CONSTRUCTION PLANS
FOR
THE RIDGE AT LORSON RANCH
SANITARY SEWER AND WATERMAIN
CONSTRUCTION PLANS

PUDSP-21-006

PROJECT:
THE RIDGE AT LORSON RANCH
FONTAINE BLVD - WALLEYE DR
COLORADO SPRINGS, COLORADO

SHEET NUMBER
C8.62

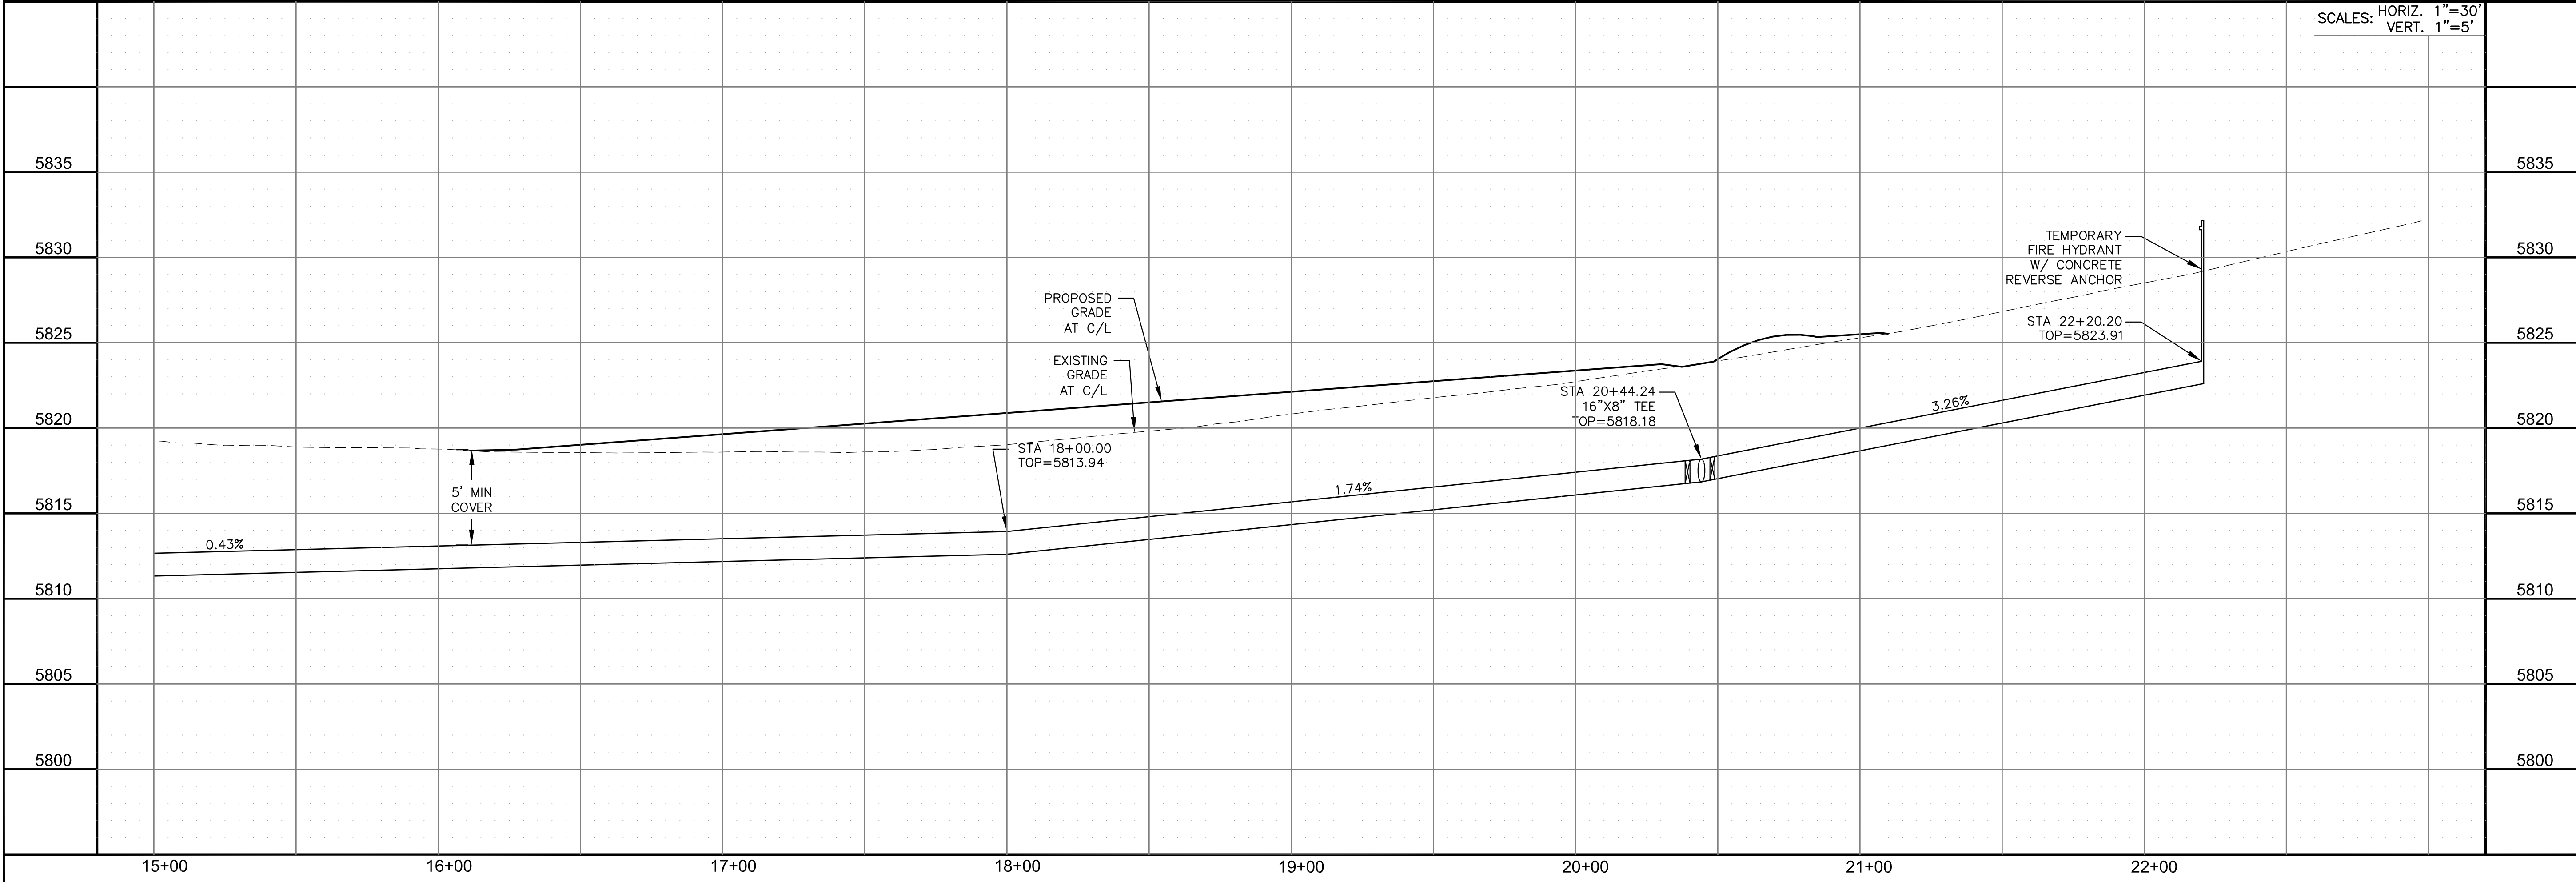
PUDSP labels this area as "future development tract" -- will the 16" water main be moved in the future?
